Outer Dowsing Offshore Wind Farm

Appendix C4 to the Natural England Deadline 4 Submission

**Natural England's Advice on the Benthic Ecology Technical Report [REP3-018] and
the Envision Offshore Export Cable Corridor *Sabellaria Spinulosa* Image Reanalysis
Report [REP3-035]**

3rd February 2025

Environmental Statement
 Refined Biogenic Reef Areas
 Figure 4.13

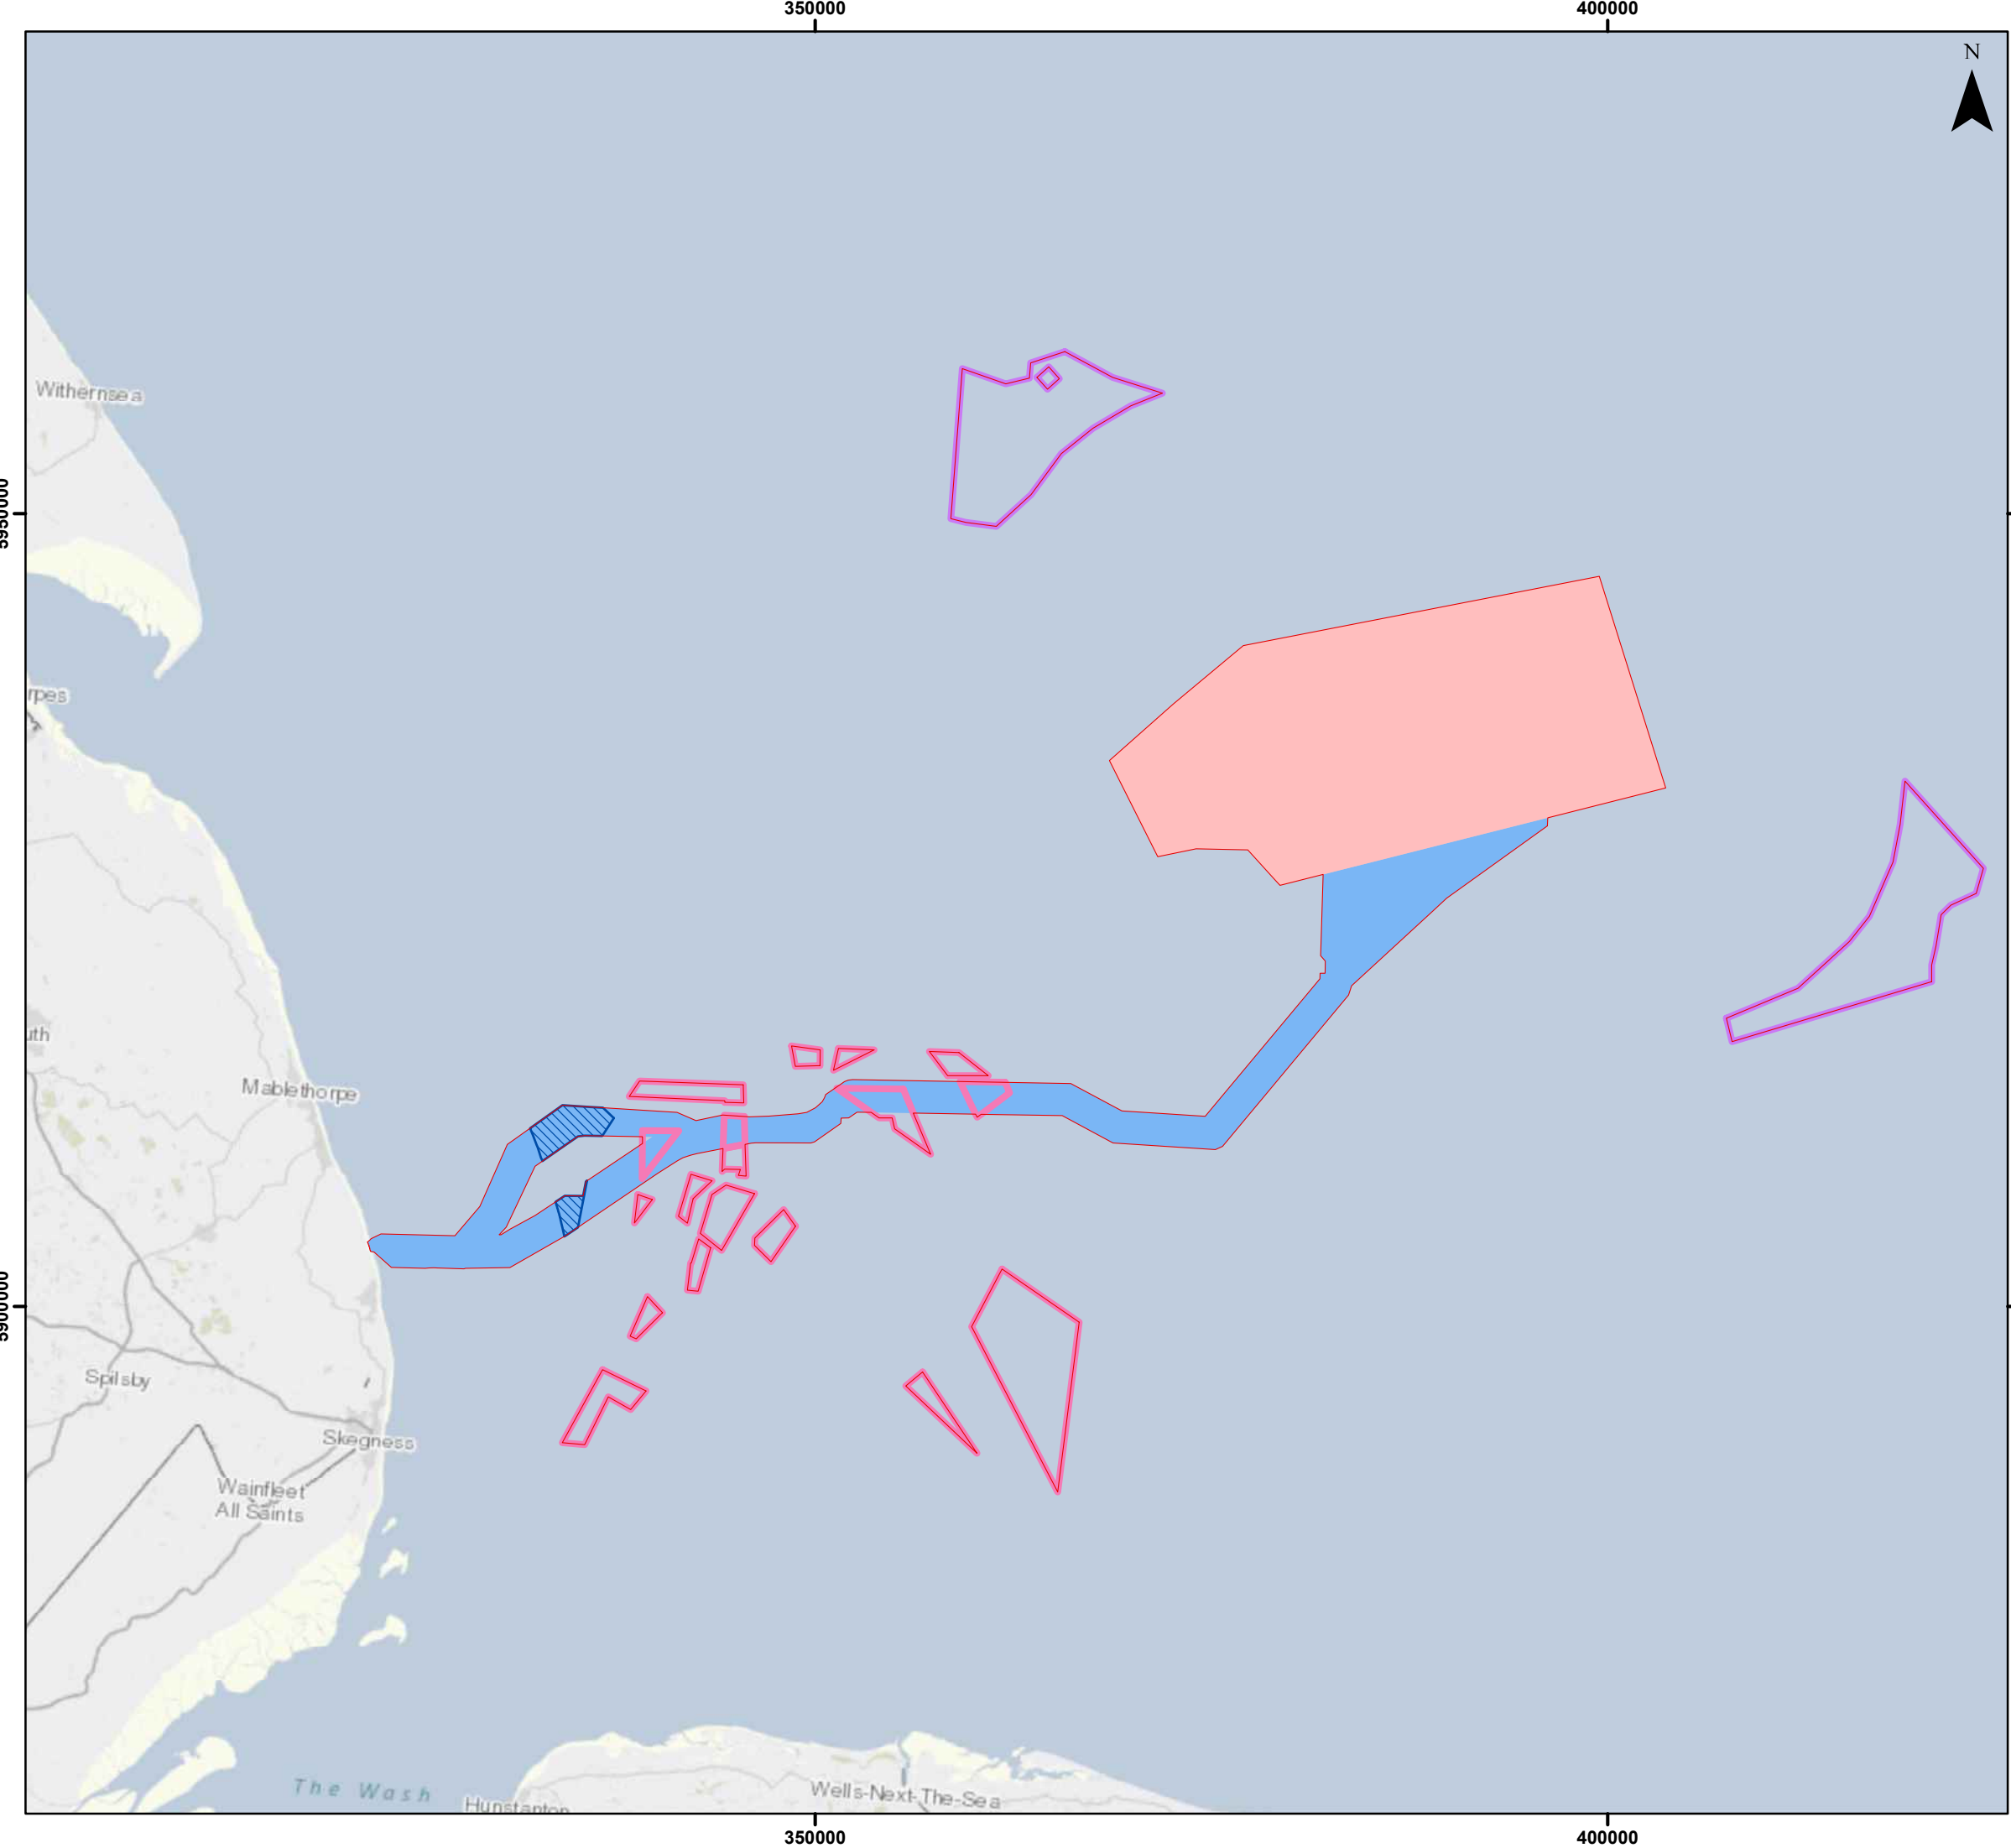
- While Natural England's concerns regarding the presence of existing reef are addressed, Natural England's position regarding supporting habitat and processes for Annex I *Sabellaria spinulosa* reef within Inner Dowsing Race Bank and North Ridge (IDRBNR) Special Area of Conservation (SAC) as advised in our relevant representations [RR-045] and at Deadline 1 [REP1-059] remains unchanged.

- Under the Supporting Processes attribute for IDRBNR SAC there is a 'Restore' target for the environmental conditions in those locations that are known, or which become known, to be important for *Sabellaria spinulosa* reef formation. We consider any lasting change/loss of supporting habitat for Annex I *Sabellaria spinulosa* reef from the placement of cable protection will hinder the recovery of this feature and therefore the ability to meet the conservation objectives for the site and would require compensation.

- We draw the Examining Authority's attention to our advice regarding supporting habitats and process for Annex I *Sabellaria spinulosa* reef in Appendix C2 [REP3-067] and Appendix C3 [REP3-068] at Deadline 3. While the Applicant is confident the export cable route can be micrositied around any existing Annex I *Sabellaria spinulosa* reef, Natural England advises the Applicant undertakes and submits into examination an assessment of supporting habitats and processes for potential Annex I *Sabellaria spinulosa* reef, to demonstrate that the recovery of this feature will not be hindered by the installation of the export cable and/or the lasting placement of cable protection. This will provide the Secretary of State comfort an adverse effect on integrity to IDRBNR SAC Annex I reef features and habitats/processes in which it relies upon will be avoided.
